## Appeal Decision

**Appeal Ref: APP/R5510/D/23/3317015**

**2 Ebury Close, Northwood, Hillingdon, HA6 2PF**

- The appeal is made under section 78 of the Town and Country Planning Act 1990 against a refusal to grant planning permission.
- The appeal is made by Mr Ameet Ramaiya against the decision of the Council of the London Borough of Hillingdon.
- The application Ref 36204/APP/2022/2805, dated 9 September 2022, was refused by notice dated 30 November 2022.
- The development proposed is a double storey rear extension. Double storey side extension to right of property. Double storey front extension. Roof configurations with two small dormers at the rear. New canopy at the entrance.

01 - GF Plan - Proposed

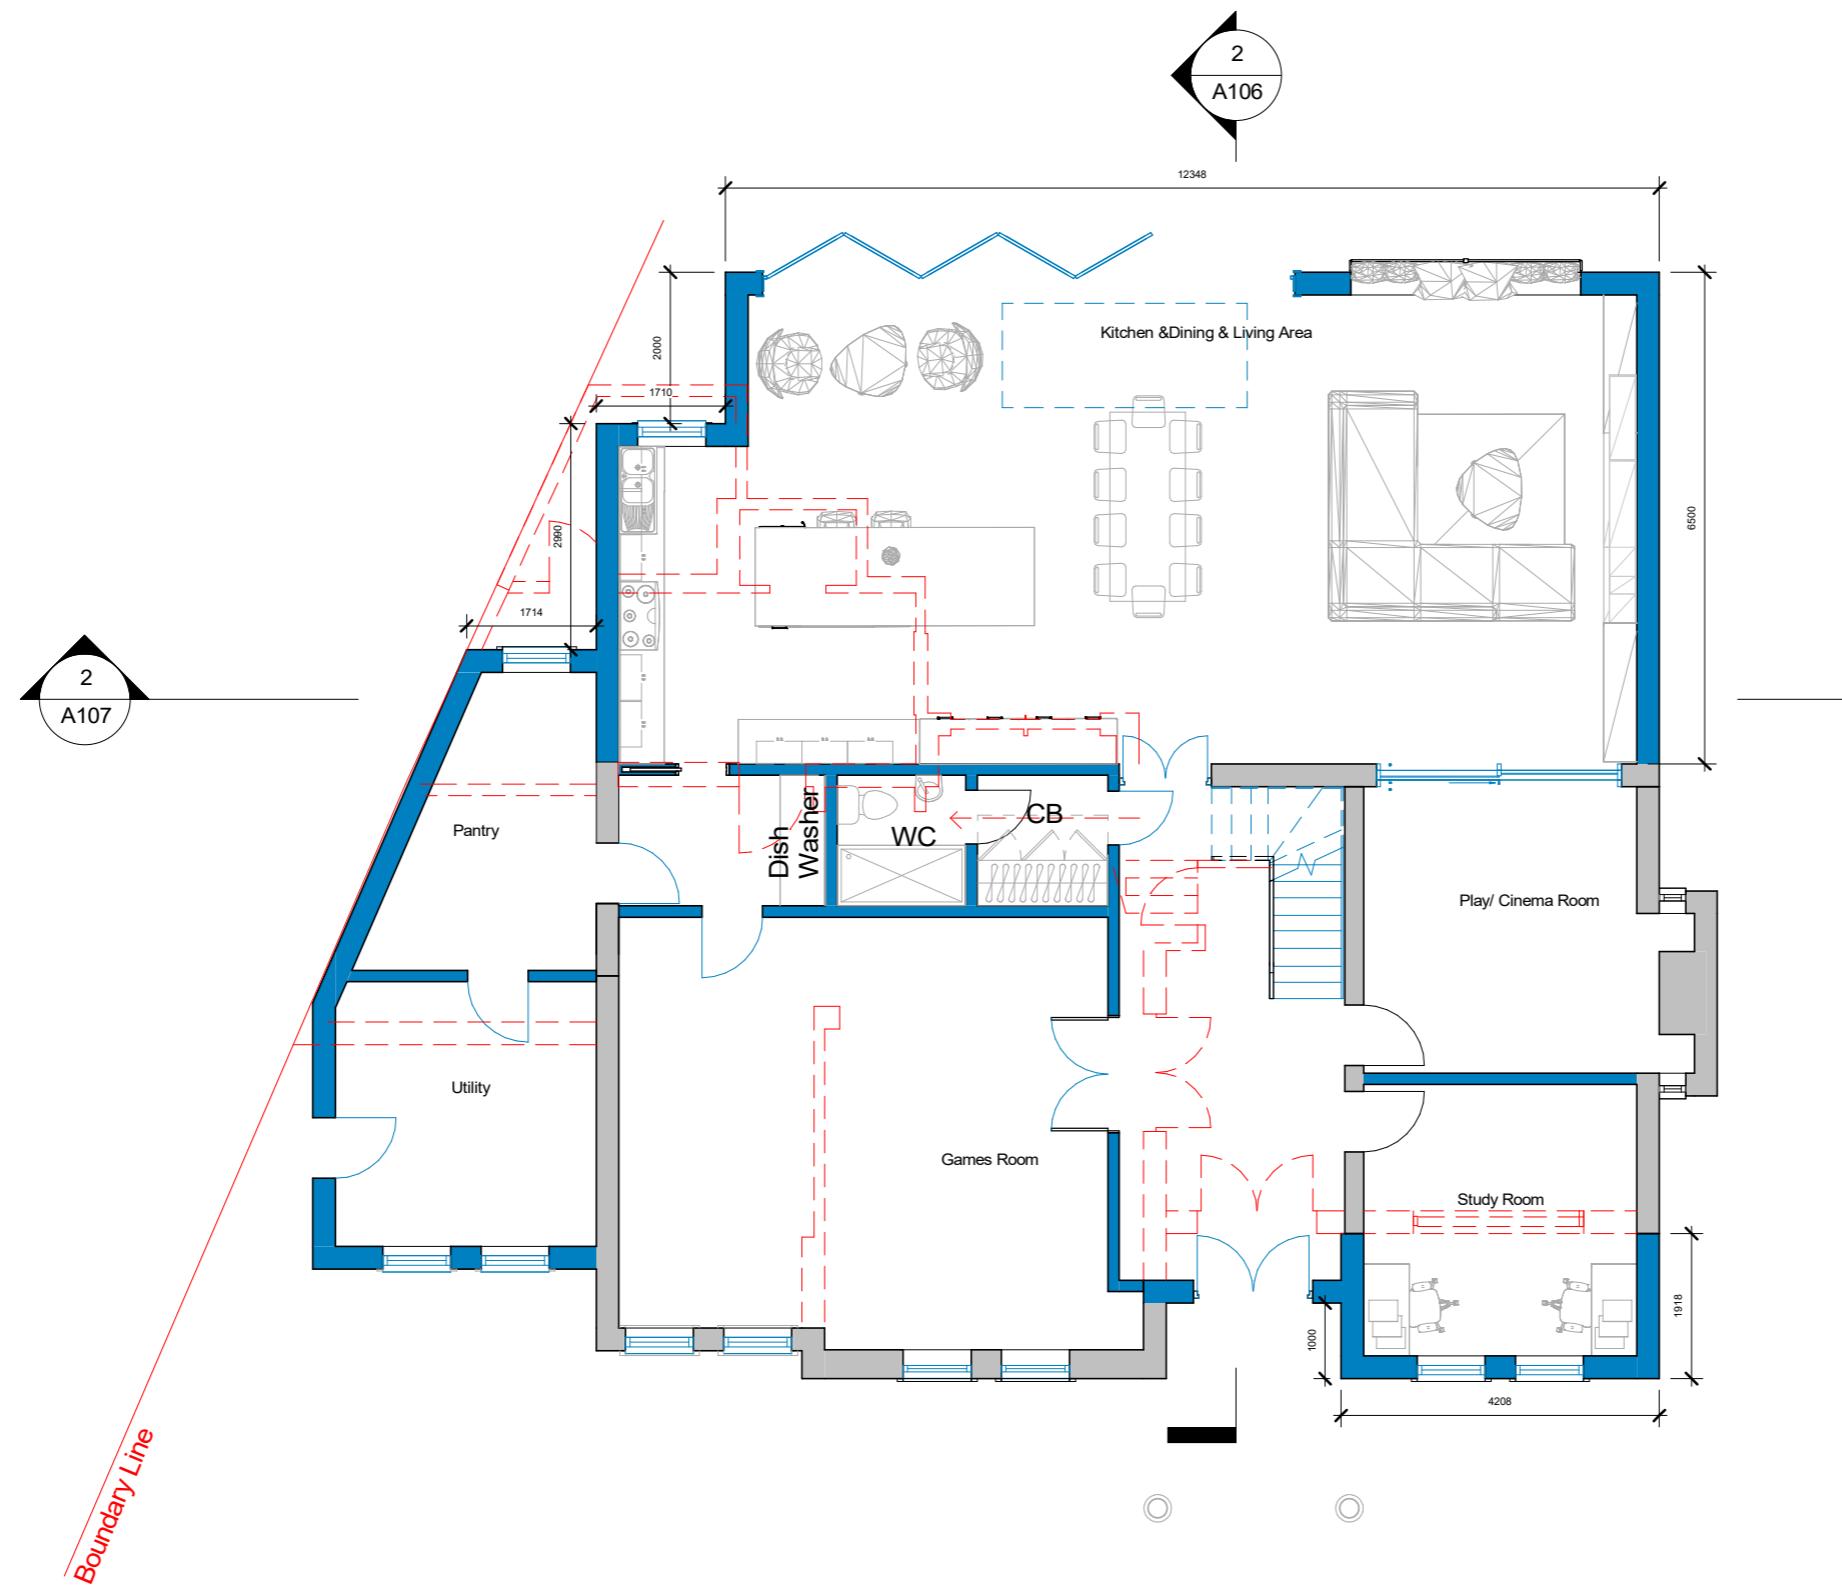
12. Further to the above, additional harm would arise as a result of the proposed front canopy appearing as a tall, bulky and prominently located forward-projection which, in combination with the proposed rear extension and roof, would add to the proposal's failure to appear subordinate to the host dwelling and would result in a development of such overall scale as to erode the spacious attributes of the area.

04 - Roof Plan - Proposed
1 1 : 100

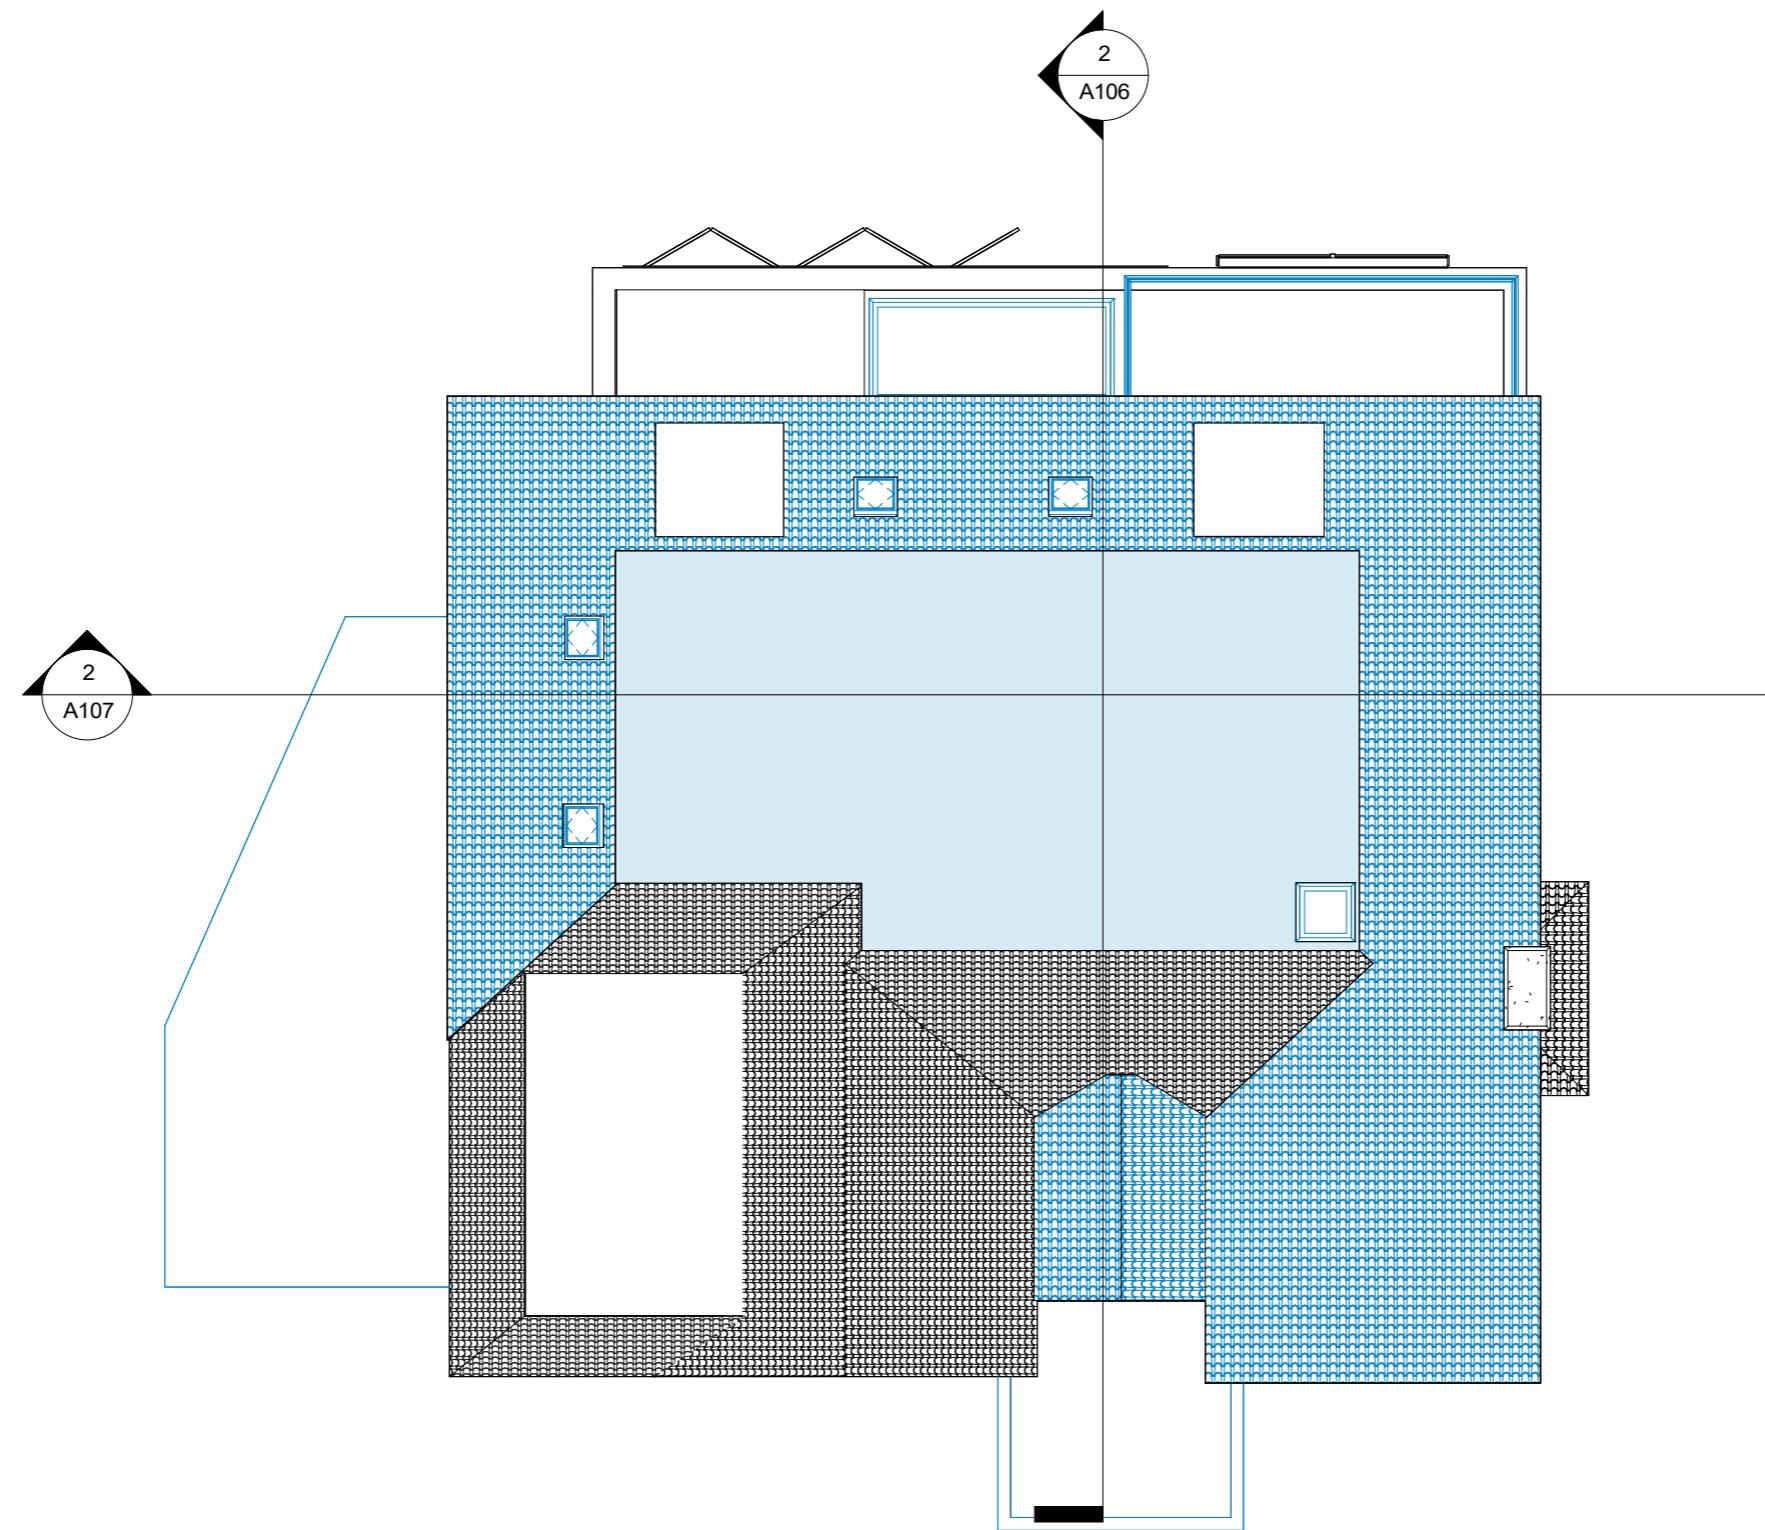
10. The proposed development would involve the considerable extension of the dwelling, including the creation of a large crown roof towards the rear, which would rise above the height of the existing main roof, resulting in an unduly awkward appearance. Further, the height and scale of the proposed roof would result in it appearing unduly prominently in its surroundings and as such, I find that it would draw attention to itself as an incongruous feature.

Proposed Rear Elevation

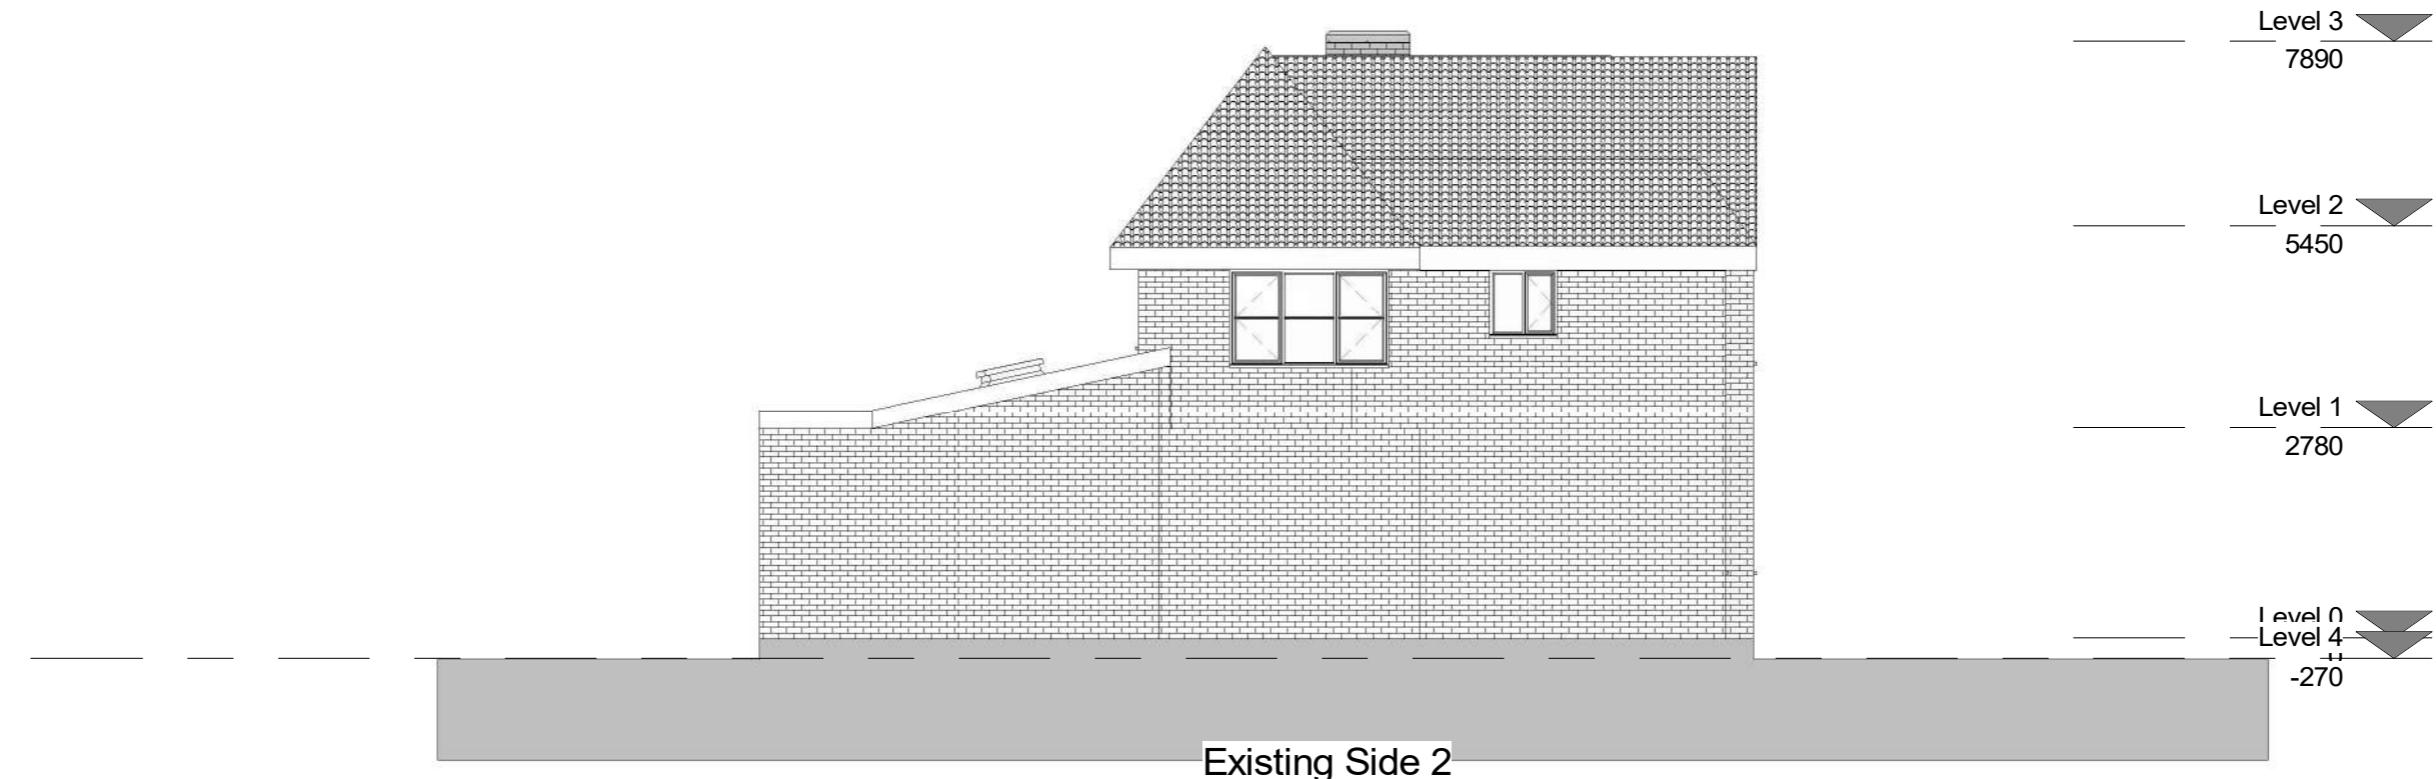
11. The harm arising as a result of the above would be exacerbated as a result of the disproportionately large extension to the rear of the dwelling, whereby the combination of the proposed roof and considerable projection to the rear at a two-storey height would result in the proposal failing to appear subordinate to, but rather, overwhelming and subsuming the original appearance of the host dwelling.
